| Application Ref: | 3/2020/0856 |  Ribble Valley Borough Council www.ribblevalley.gov.uk |
| DELEGATED ITEM FILE REPORT: | | Decision REFUSE |

| Development Description: | Conversion of existing garage to a habitable work space to carry out physiotherapy and use as a home gym |
| Site Address/Location: | 4 Meadow Croft, West Bradford |

4 MEADOW CROFT GARAGE CONVERSION

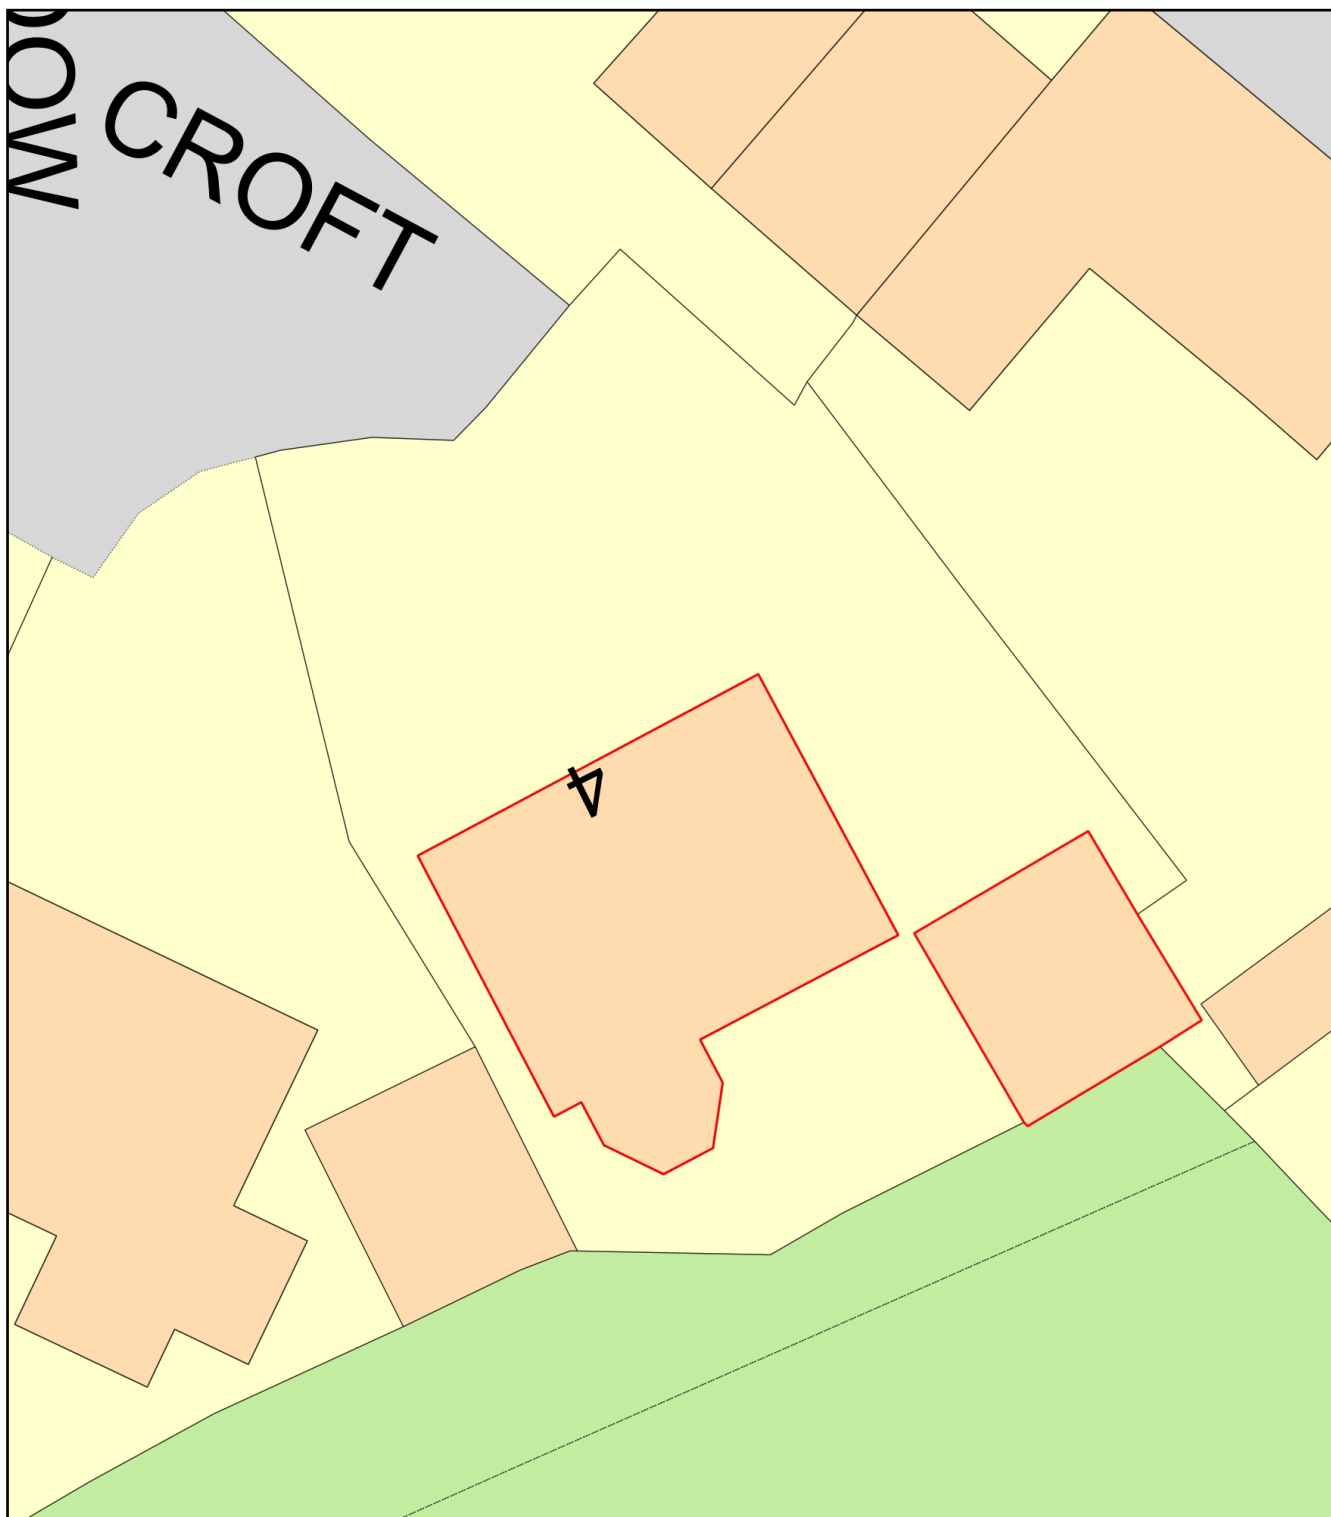
The highway engineer has asked for a plan showing driveway parking spaces, with 3 for the dwelling and one customer space that are independently accessed from Meadow Croft. Conditions to ensure appointments are 1:1 and with a 15-minute gap between appointments. They state that this information is provided satisfactorily that they would not raise an objection.

This information has now been provided and the applicant has explained that if customers are visiting that her car would be on the driveway so there would be no problem with a car parking behind it. A plan shows 4 spaces with only two in tandem.
